## MEMORANDUM

**TO:** Nell Donaldson, Planner  
**FROM:** Lauren Swett, PE  
**DATE:** October 7, 2016  
**RE:** 30 Merrill Street, Level III Site Plan Application

Woodard & Curran has reviewed the Site Plan Application for the proposed development located at 30 Merrill Street in Portland, Maine. The project involves the construction of a four story residential building with parking in the rear of the lot.

PERVIOUS PAVEMENT SECTION DETAIL
NOT TO SCALE

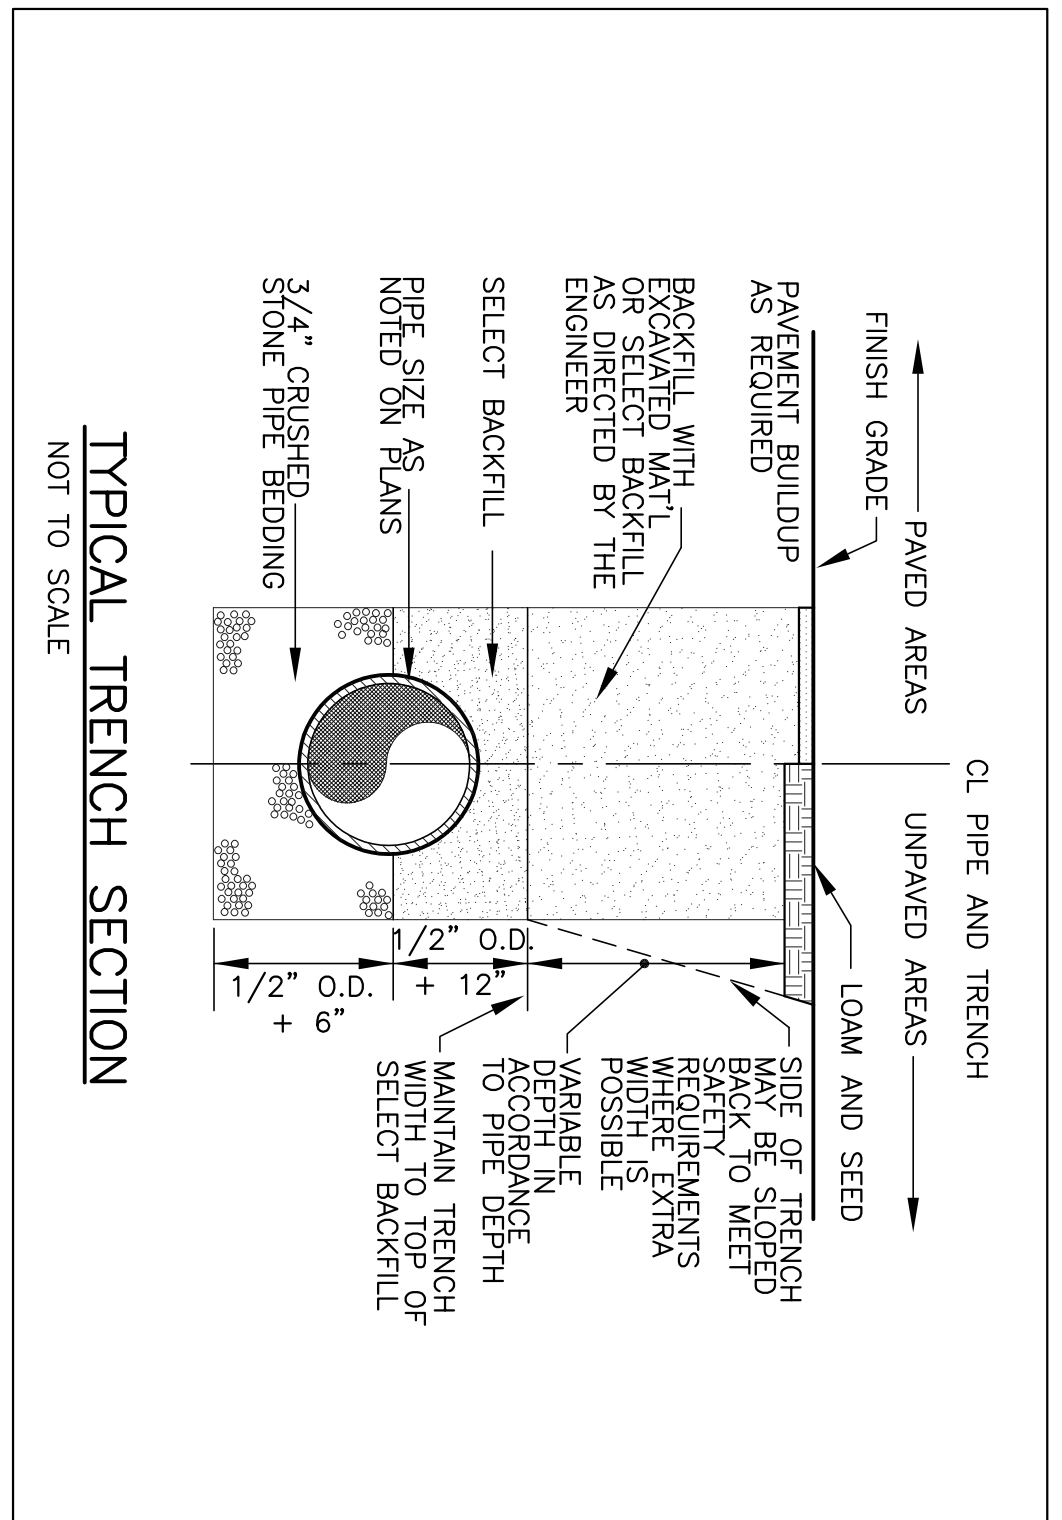
- b) General Standard: The project will result in a de minimis increase in impervious area. Treatment is not required; however, the Applicant has proposed pervious pavers to provide treatment for the parking area.

EROSION CONTROL BLANKET

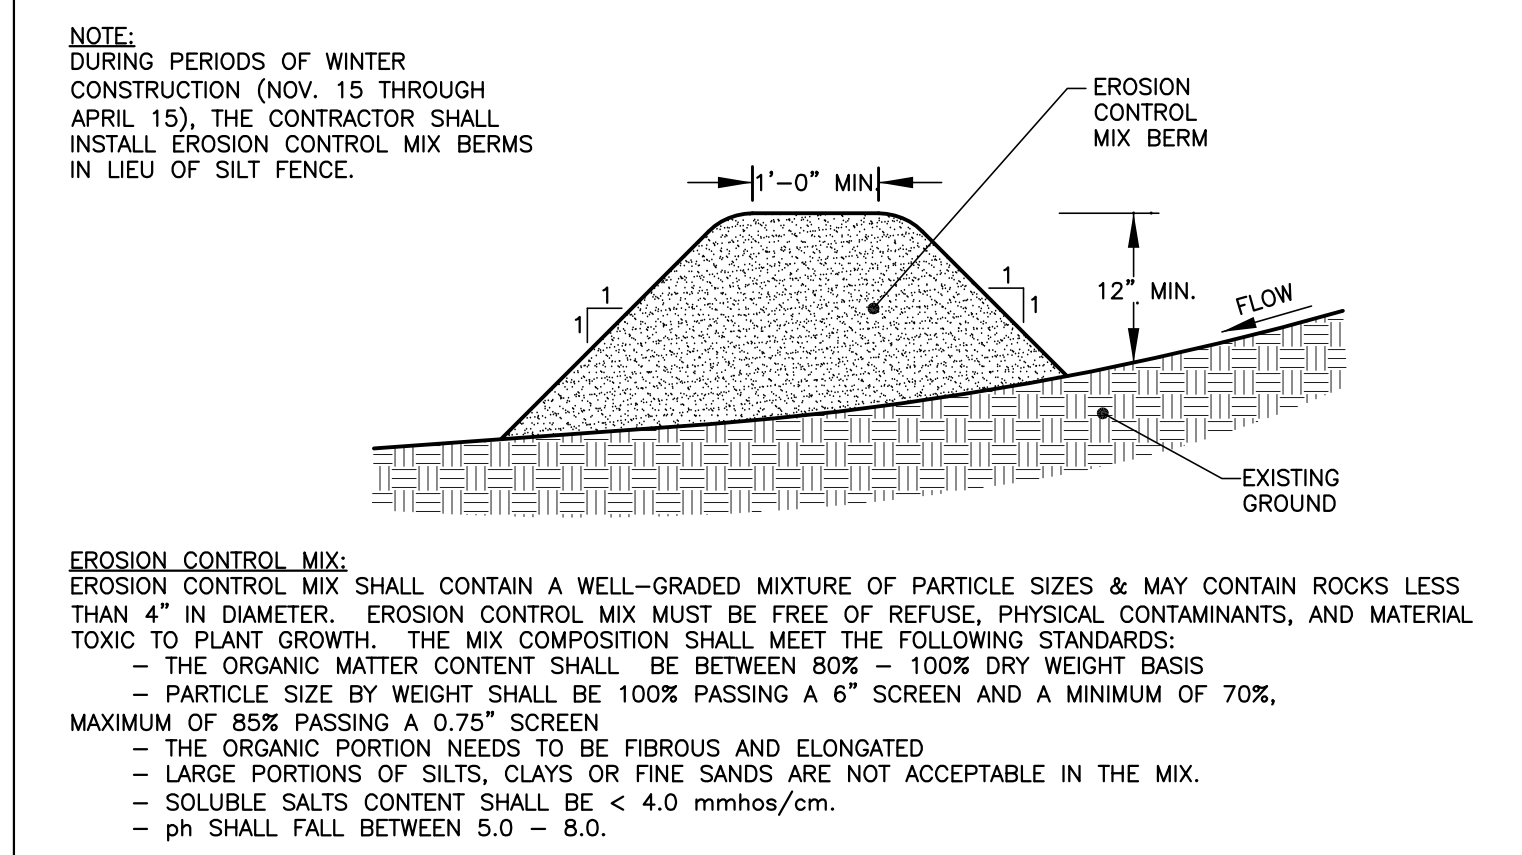
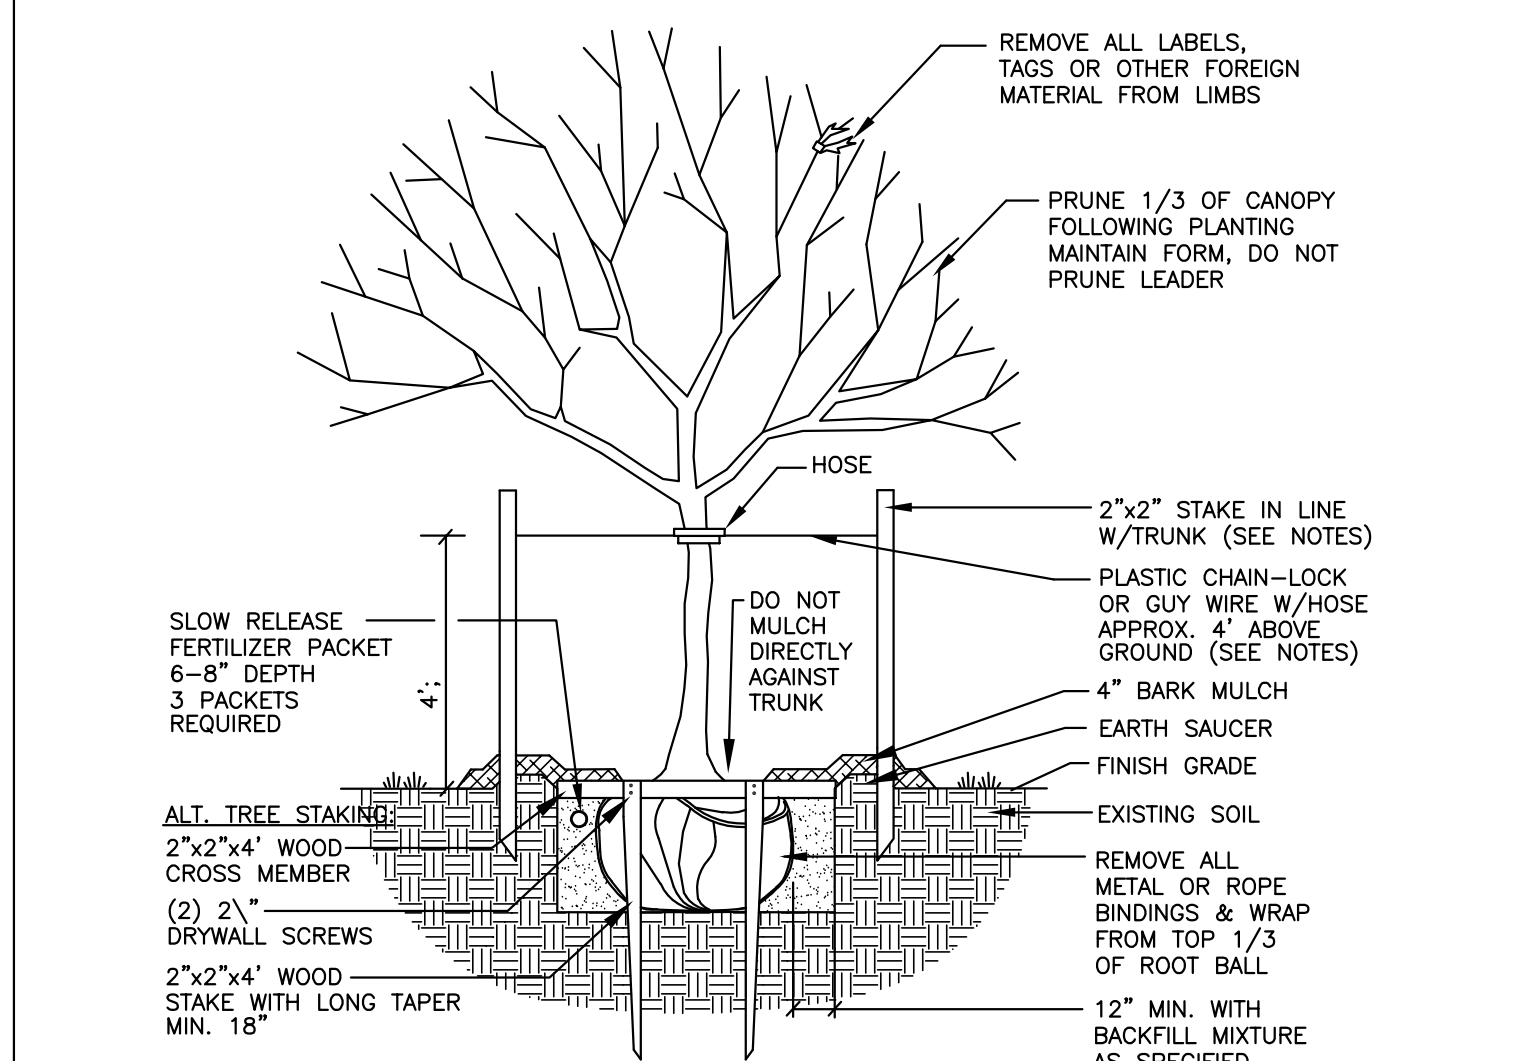
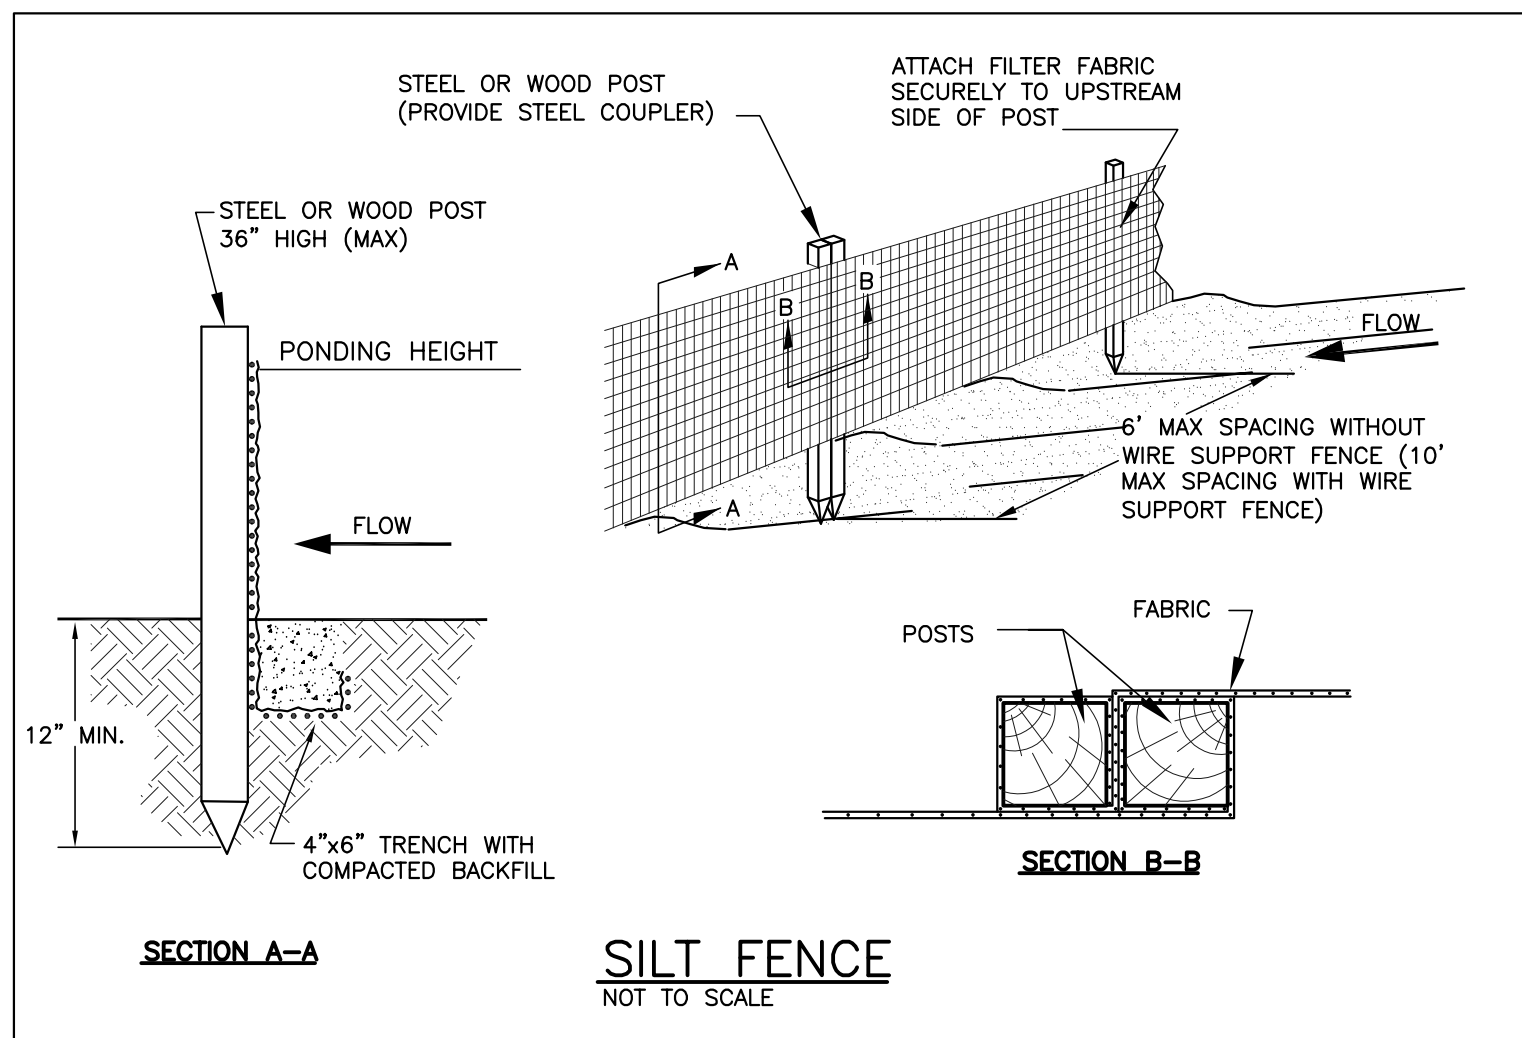
- a) Basic Standard: The Applicant has provided Erosion & Sediment Control notes and sedimentation barrier details to address erosion and sediment control requirements, inspection and maintenance requirements, and good housekeeping practices in accordance with Appendix A, B, & C of MaineDEP Chapter 500.
